## MECHANICAL SYSTEMS ENGINEERS

March 13, 2015

Re: 118 on Munjoy Hill – Requirement of an oil/water & grit separator

10 PRECAST CONCRETE OIL/GRIT SEPARATOR DETAILS

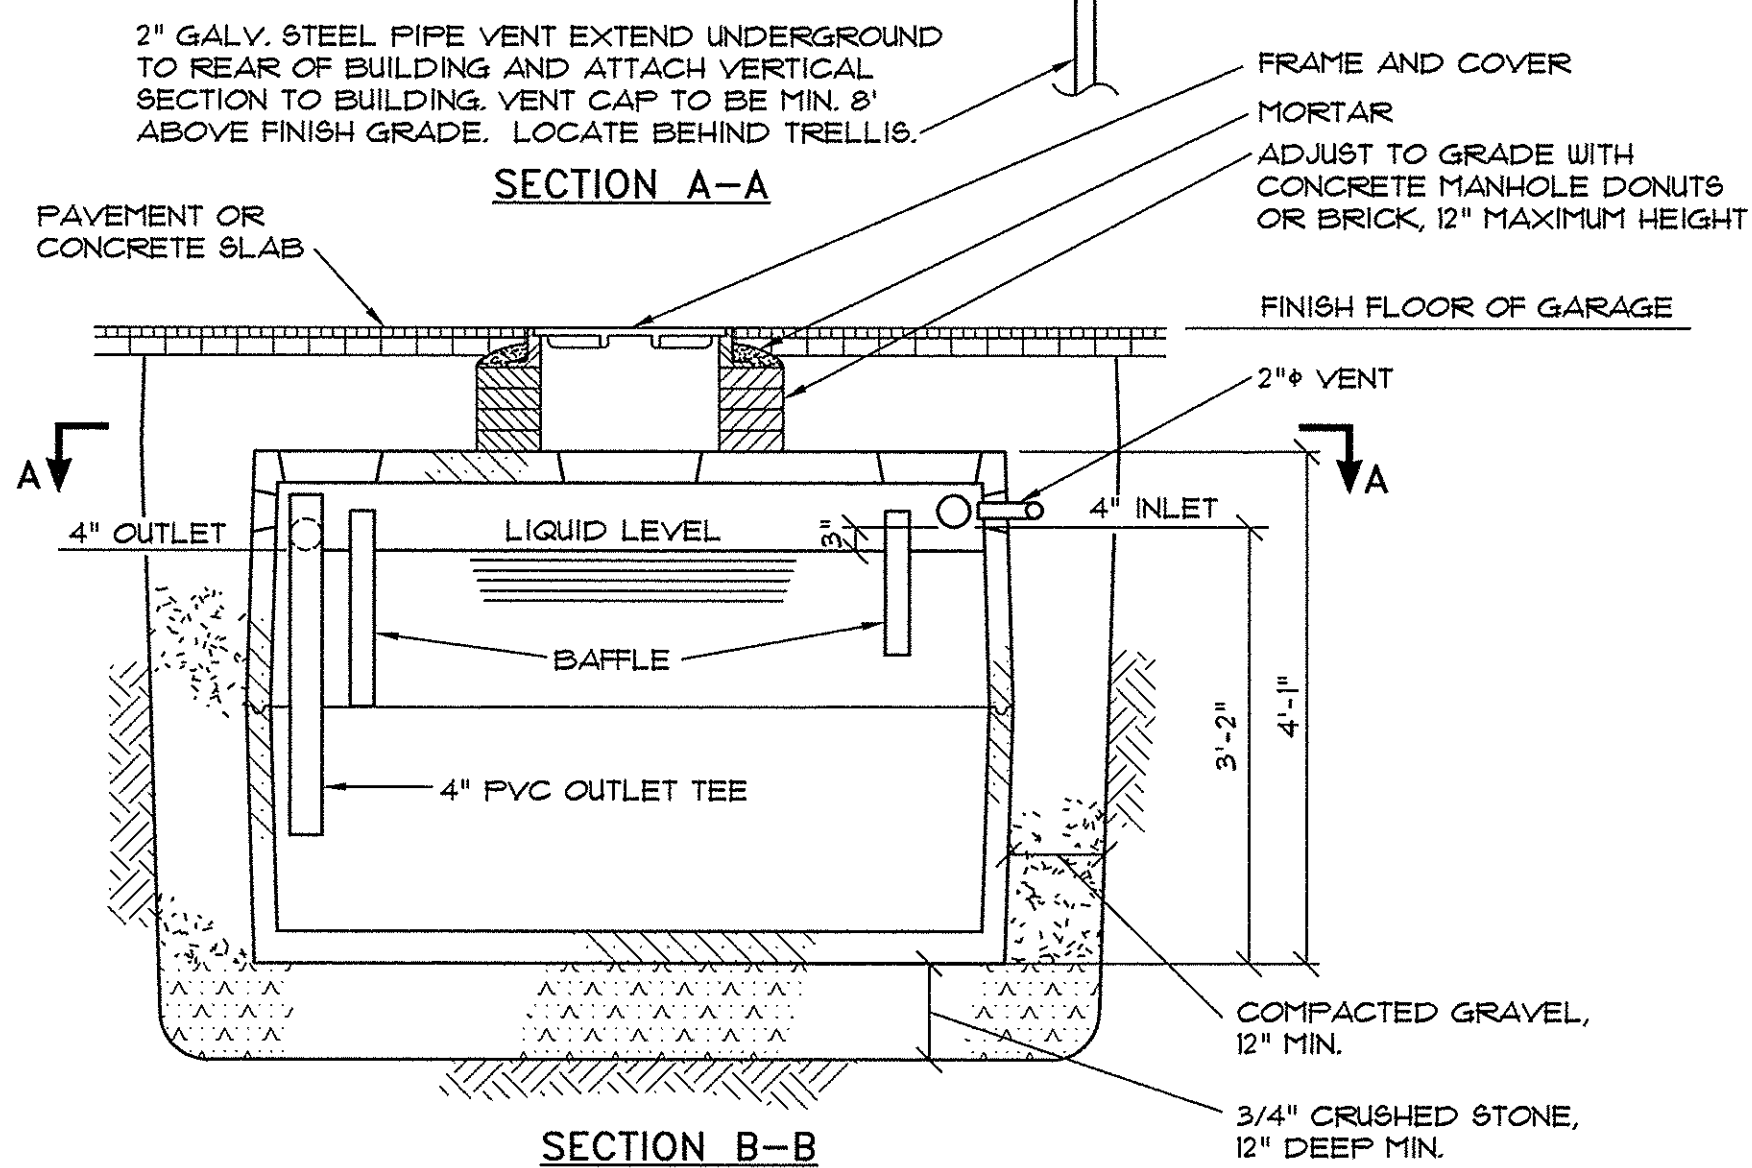
We have reviewed the conditions of the interior parking garage floor drains, and disagree with the necessity of an oil and grit interceptor for these floor drains that flow to the sewer system.

As we understand it, the preliminary design presented to the planning board had these parking drains as part of the overall Stormwater plan. If this had been an outside parking lot, or open walled covered parking area, that would have been correct, but this parking space is entirely enclosed and never receives any rain or run-off. Instead of the 13,000 gallons per hour run-off possible in the 100 year storm from a typical exterior parking lot, here less than 1 gallon per day is expected from any dripping vehicles. In fact most of water drips on these vehicles are expected to evaporate.

Regardless of what was proposed to the planning board, once an area is totally enclosed by the building it falls under the jurisdiction of the Maine State Plumbing Code, rather than any site stormwater plan. According to the Plumbing Code an indoor parking does not require an oil or grit interceptor, except in cases where the vehicles are expected to be washed or serviced. No vehicles will be allowed to be wash or serviced inside. Any concern that the vehicles of these well-to-do residents might drip oil cannot be a serious one. However, if the issue is pushed, the amount of oil is well below the 100 milligrams per liter level of hydrocarbon oils listed in Portland's Chapter 24, Section 24-17. Also according to Section 24-48, if the public works authority does require pretreatment, then the design and installation shall be subject to its review and approval subject to the provisions of the state plumbing code, and the Plumbing code does not require it.

As for preventing the sand/grit from washing into the sewer system, please note that unlike an exterior parking lot that is heavily sanded after every snowstorm, the tiny amount of sand here is only that which will be carried into the garage on tires and undercarriages. Also since there is no rain inside the building, there is not sufficient flow to move the sand to the drain. The owner will hire a sweeper annually to clean the sand off the floor. Any sand that does land directly on the floor drain grid itself will be caught by the large sediment bucket inside the floor drain.

I recommend that this be appealed to City Manager (within the 10 days of the date of the written notice of violation) according to Section 24-57.
